City of Albuquerque Stormwater Construction Site Inspection Report

ESC File No.	M09E012B	Project Name:	98th & Sage Storage Frontera
NPDES Id. No.	NMRT0066R	Location:	9850 De Vargas Rd SW
2/20-21/2025	Owner	Contractor	
Operator	FRE Albuquerque SS, LLC	GYS General Contracting	
Contact name & title	Bryan Grissinger & Todd Megrath	David Harvey & Ian Ring	
e-mail	bryan@frontearearealestate.com	david.h@gysgeneralcontracting.com	
Contact Phone #	619-756-4622	719-510-4202 / 913-302-7409	
COA Inspector	Chancellor English	Start/End Time:	12pm
Construction Phase:	paving		
Type of Inspection:	<input checked="" type="checkbox"/> Regular	<input type="checkbox"/> Storm Event	<input type="checkbox"/> Post Storm Event >0.25" <input type="checkbox"/> 311/Complaint <input type="checkbox"/> Follow Up
Weather at time of inspection?	Clear	Temperature:	~ 55
Estimated date of last storm 0.25" or greater	11/7/2024

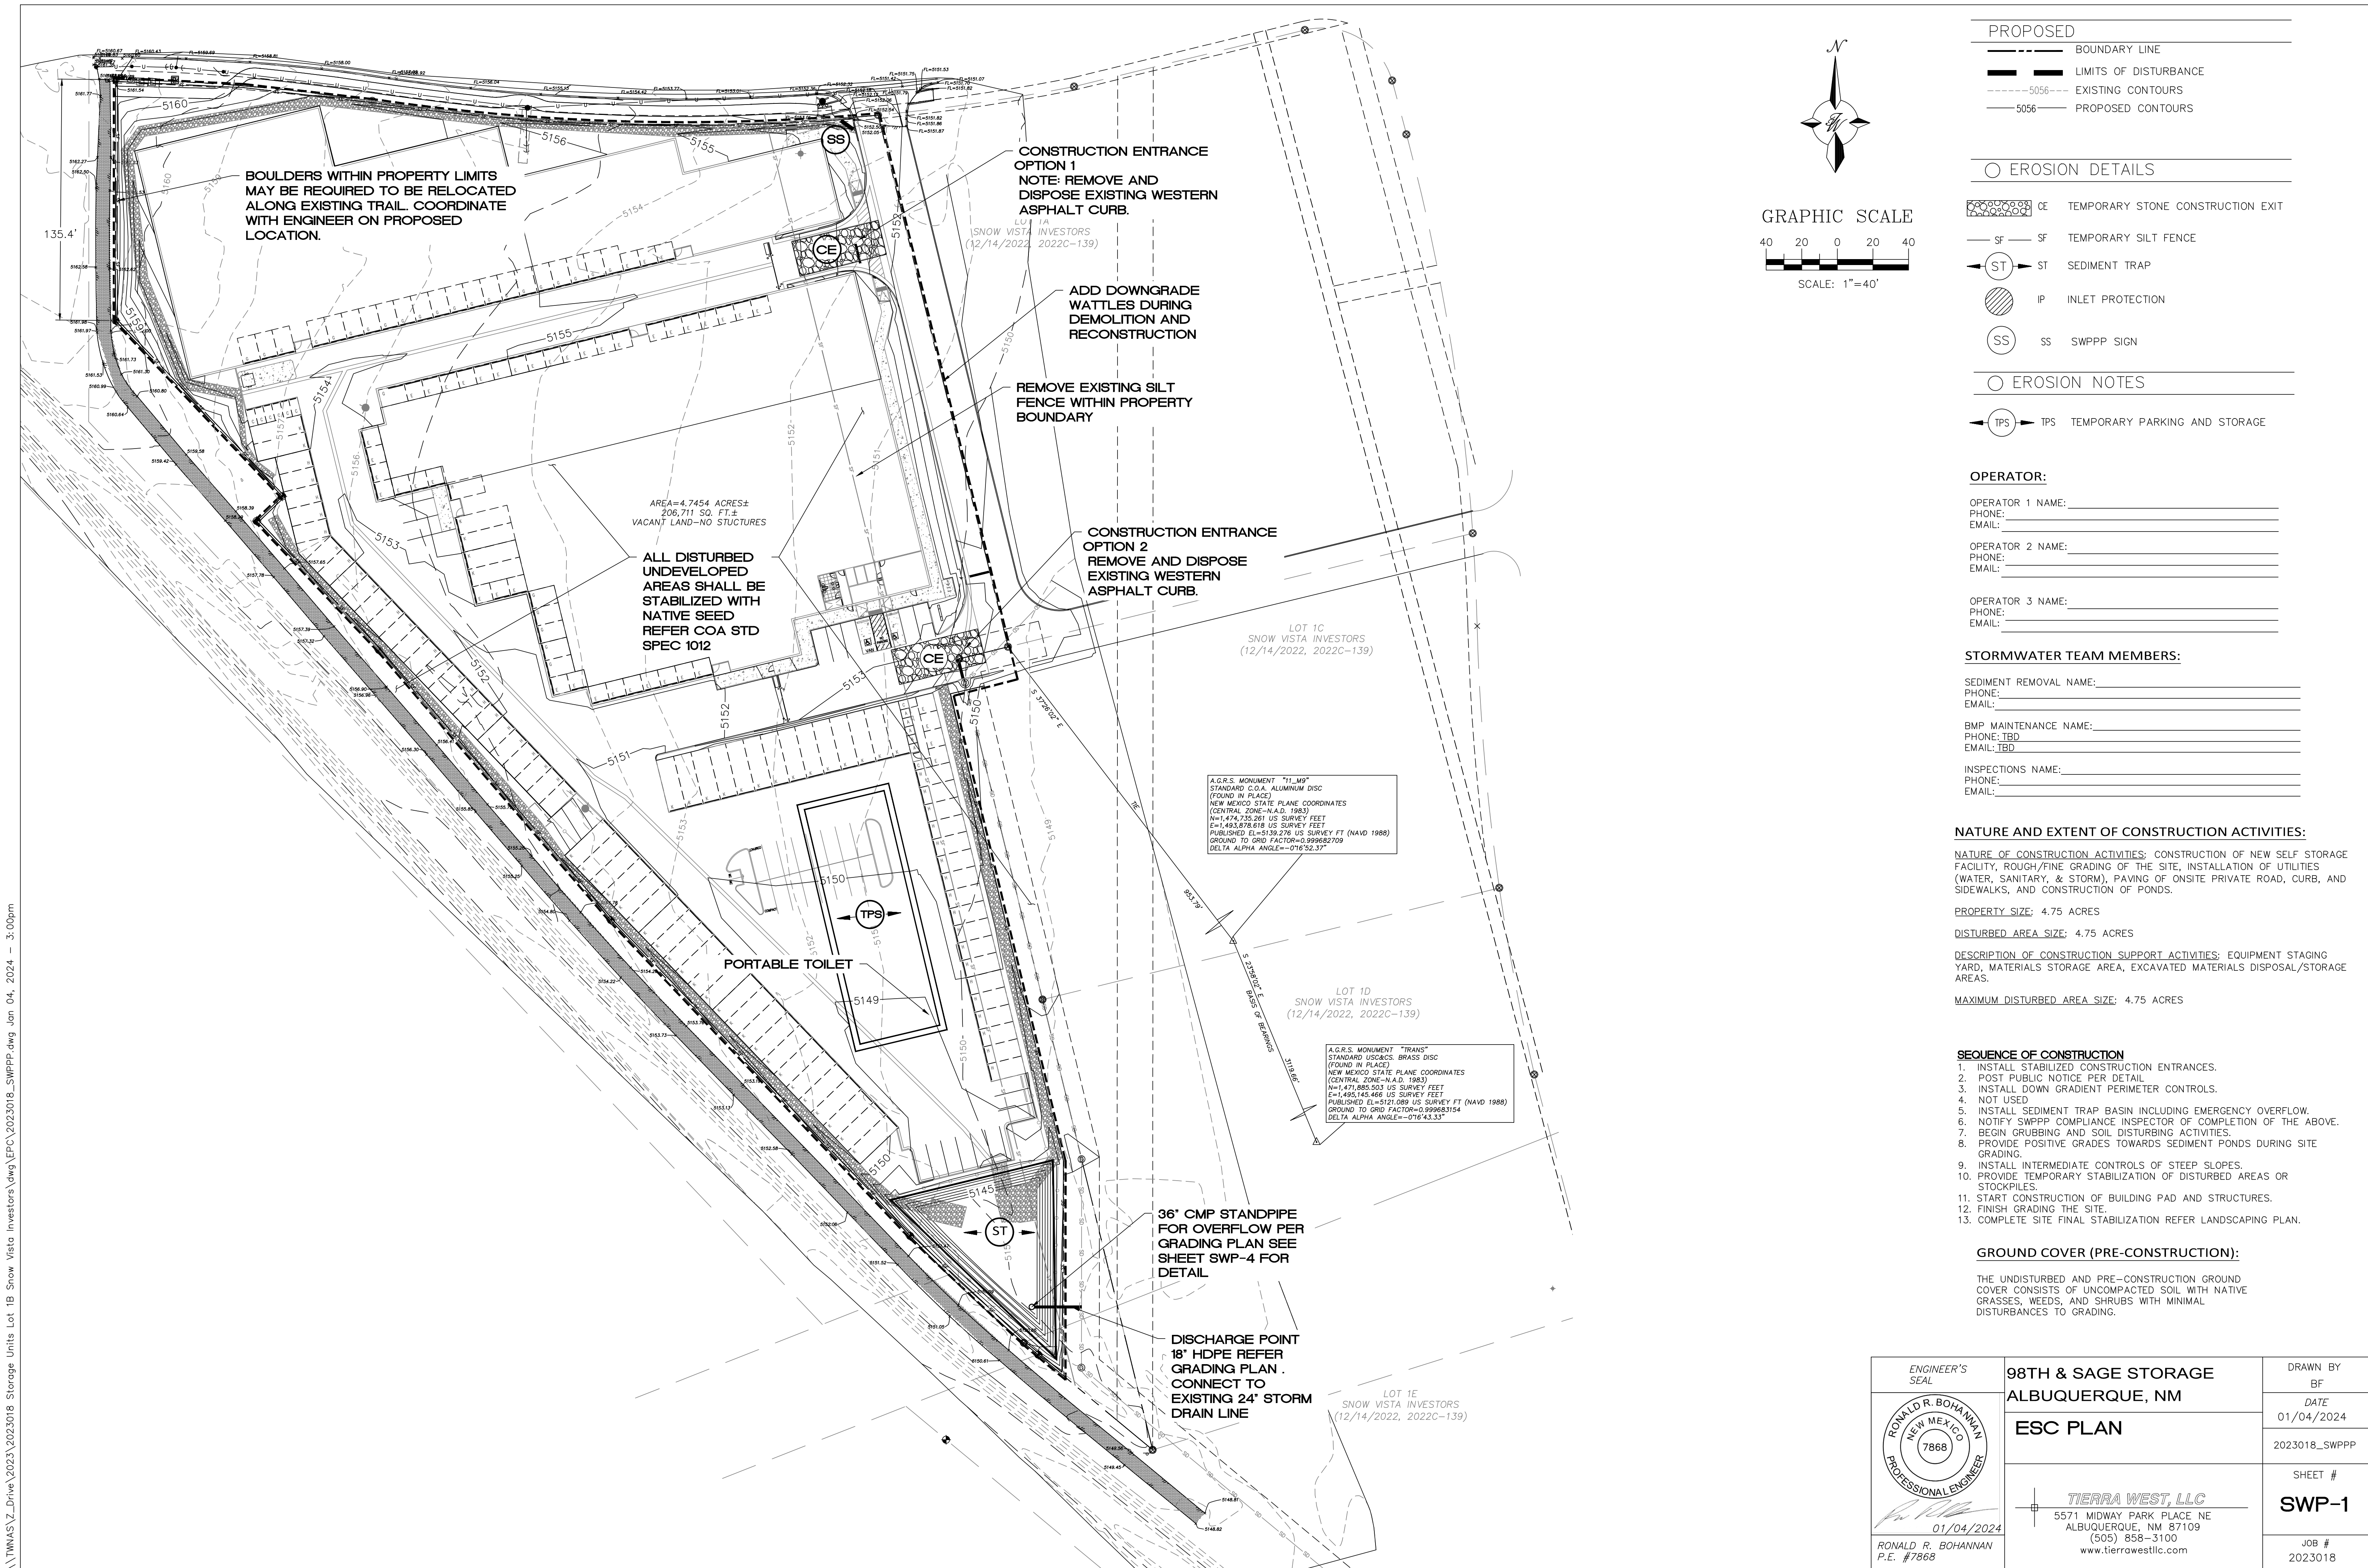
Item Number	Deficiency/ Corrective Action		
1	The SWPPP is not current - The SWPPP Map does not include the construction use of the neighboring property (vehicle and equipment parking, materials and waste) in violation of CGP Part 7.4.1 and the inspection reports available for inspection were not up-to-date in violation of CGP Part 4.7.3. The General Contractor and the neighboring property owner have NOIs that need to be included in the SWPPP in violation of CGP Part 7.2.11. Required mitigation*: You must modify your SWPPP, including the site map(s), within 7 days whenever you make changes to your construction plans, stormwater controls, or other activities at your site that are no longer accurately reflected in your SWPPP per CGP Part 7.4.1.a. You must keep a copy of all inspection reports at the site or at an easily accessible location so that it can be made immediately available at the time of an on-site inspection per CGP Part 4.7.3. All operators must include, in the SWPPP, a copy of their NOI submitted to the EPA per CGP Part 7.2.11.

Notes:	The SWPPP is located in the construction office
*There are 2 options for mitigating the violation related to construction activity occurring on the neighboring property: Either 1) provide the neighboring property owner's NOI and amend the SWPPP Map to reflect the usage (as stated above) or 2) remove all materials and equipment from the property and stabilize the disturbed land outlined in CGP Part 2.2.14.c.
